# CITY OF PORTLAND

# BUILDING PERMIT

Job ID: 2012-04-3820-SF

has permission build a 26 by 32 foot Single Family Residence.

**SITE PLAN**  
OF:  
**BRAASCH PROPERTY**  
25A SUMAC STREET  
PORTLAND, MAINE  
FOR:  
**CONSTRUCTION SYSTEMS OF NEW ENGLAND**  
5 REAR INDUSTRY ROAD  
SOUTH PORTLAND, MAINE 04106

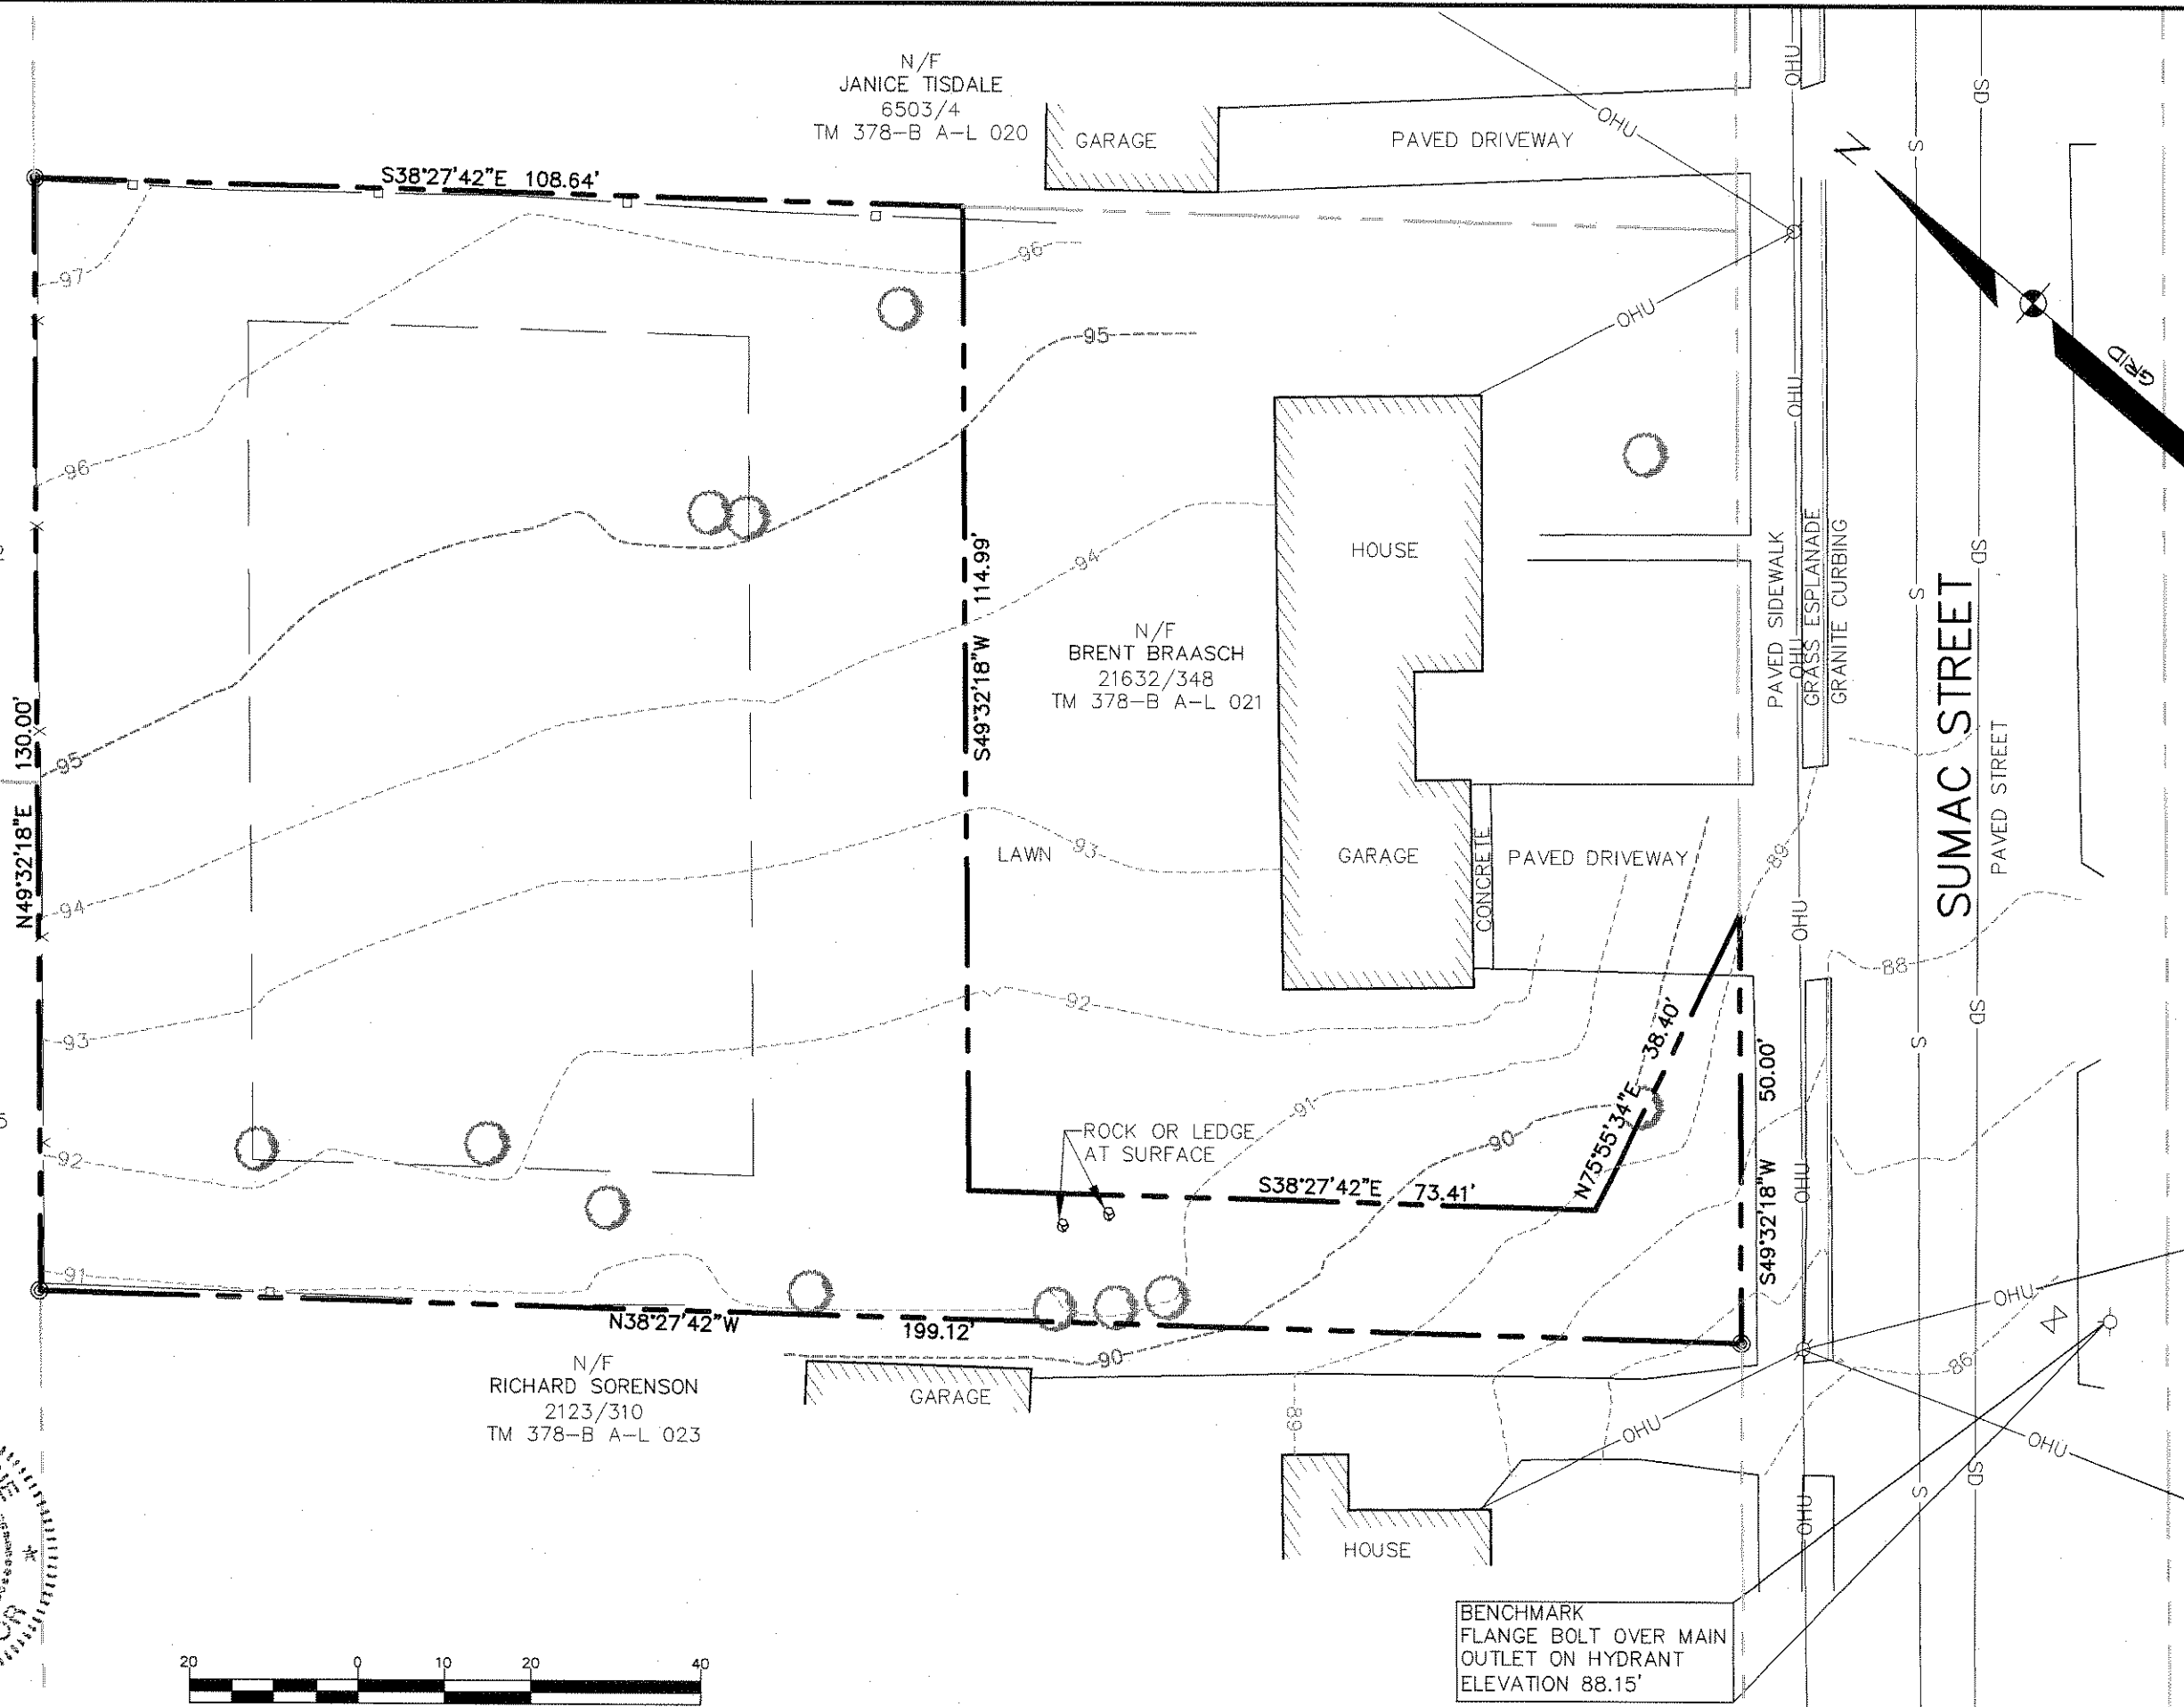
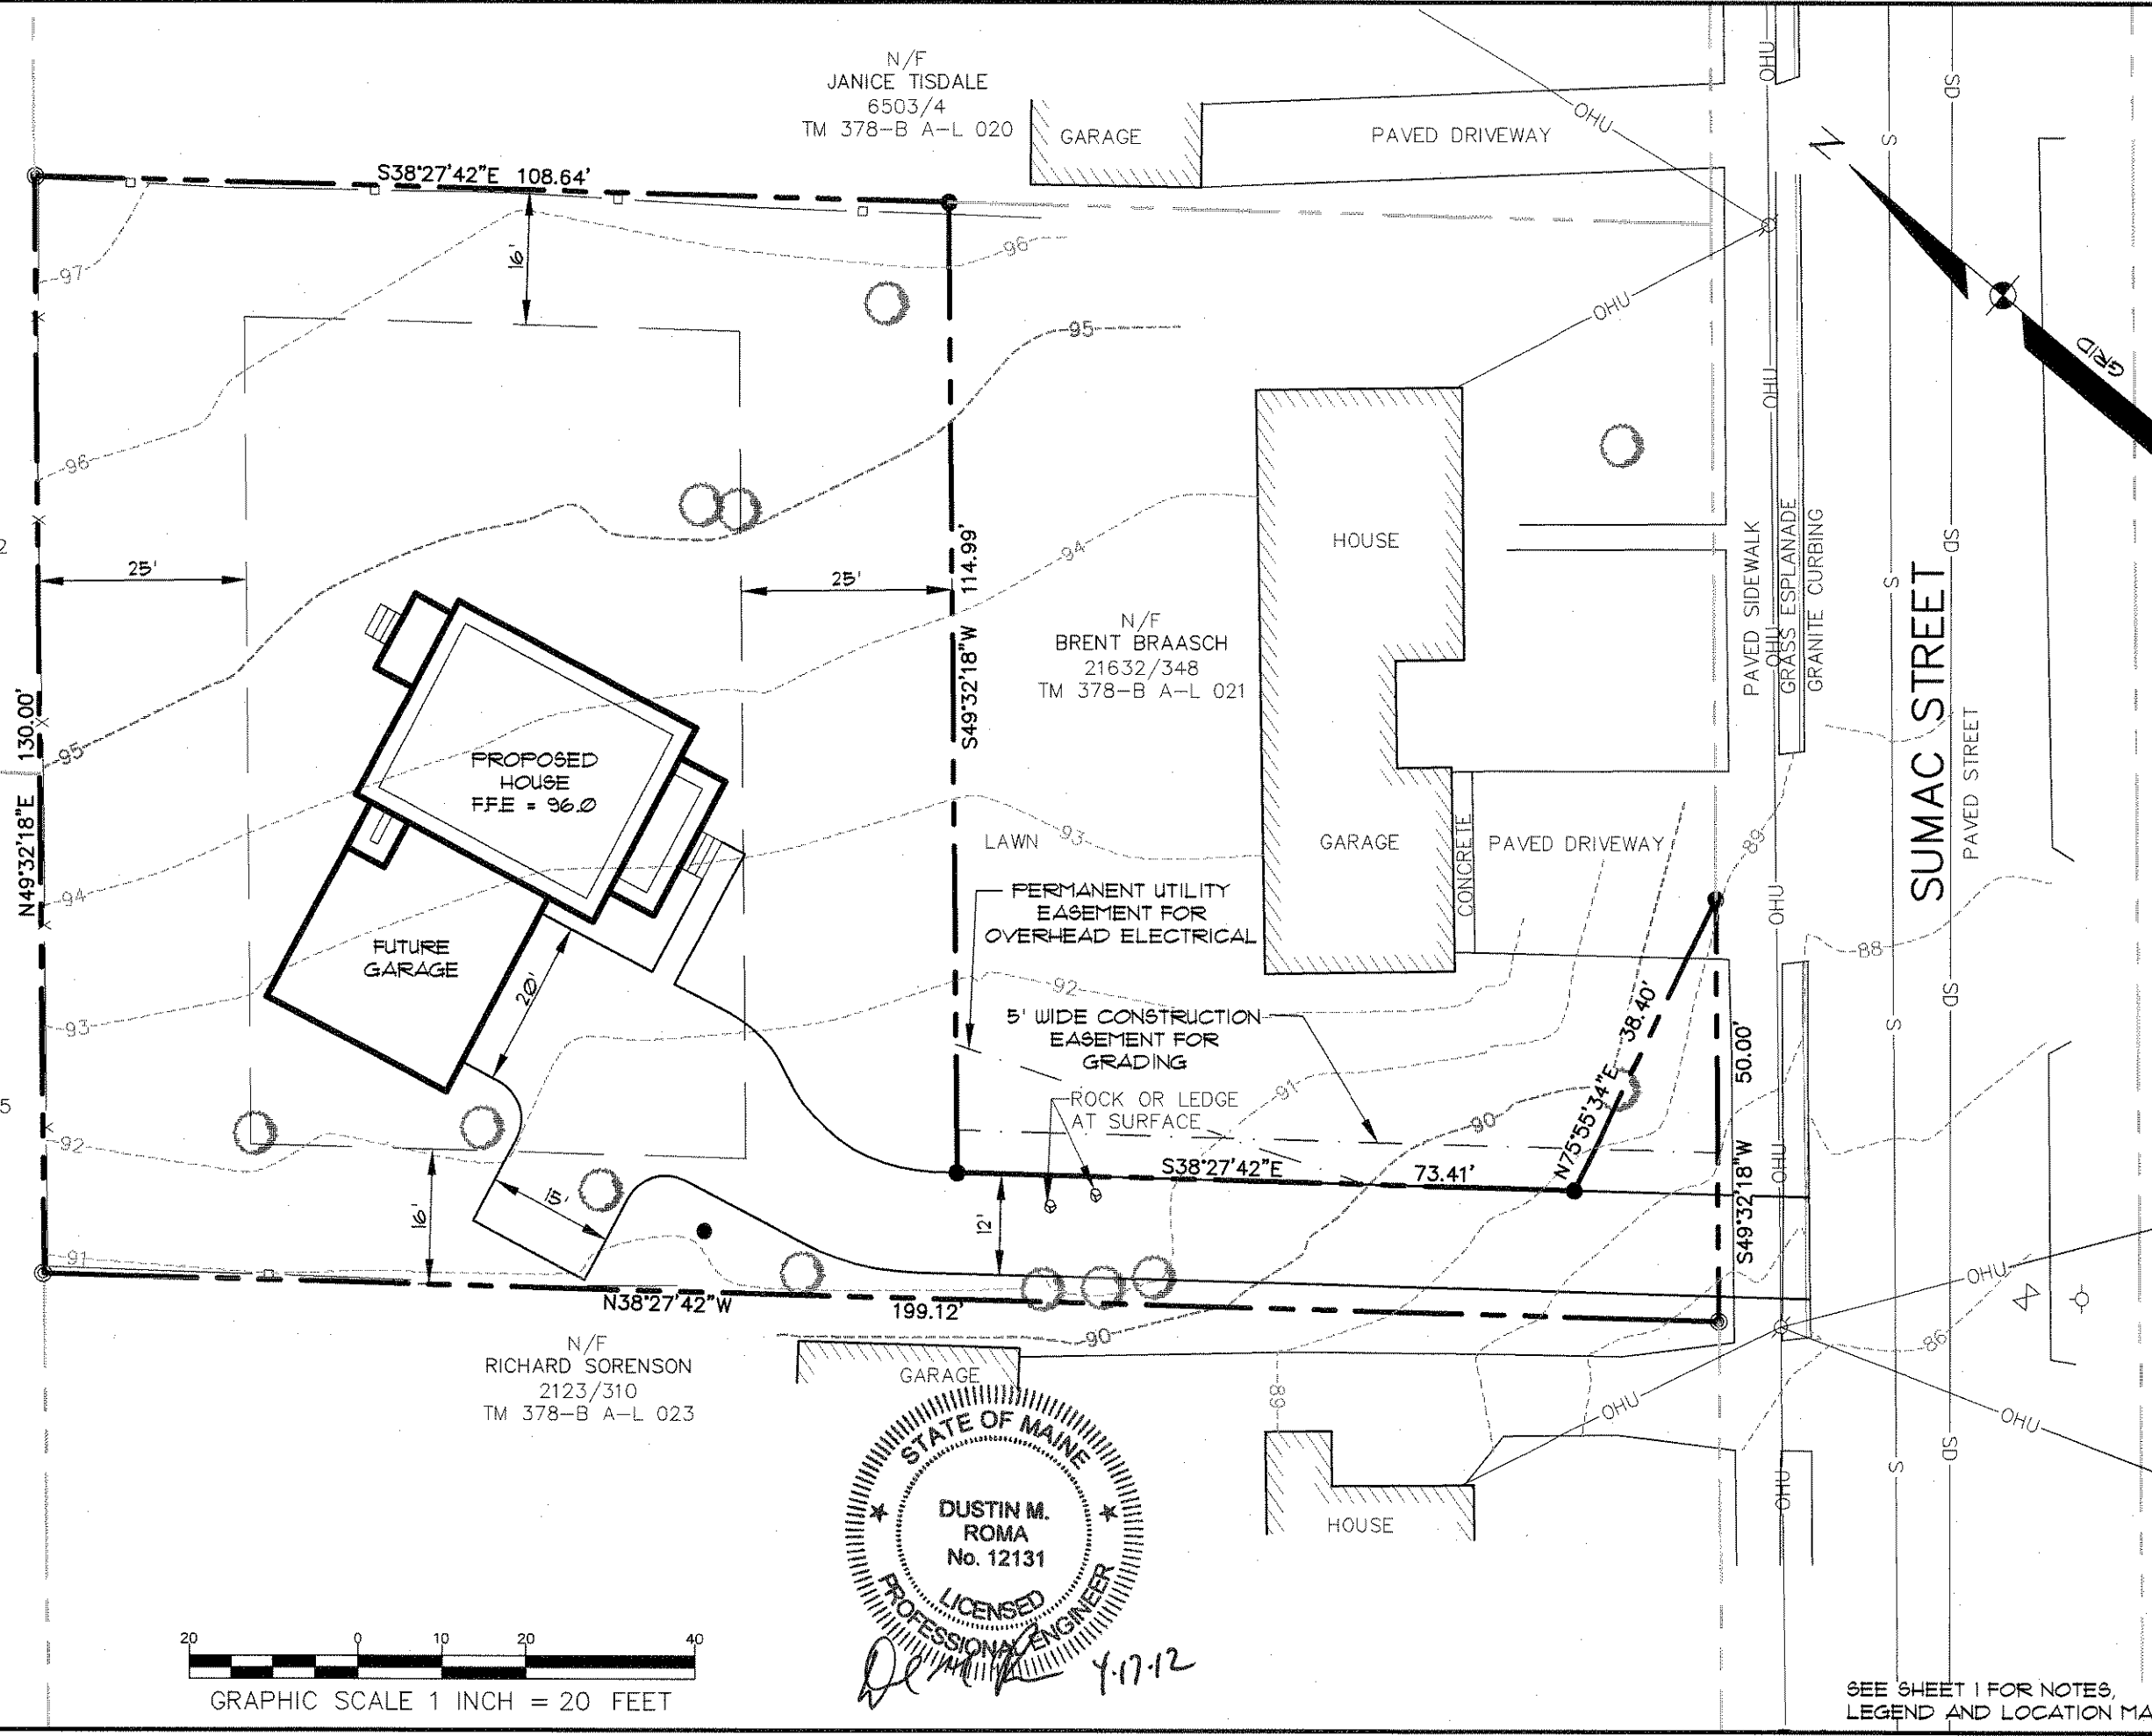
1. Please submit a revised site plan that includes the following information:
  - Please remove the garage footprint from the plan since it is not proposed to be built at this time.
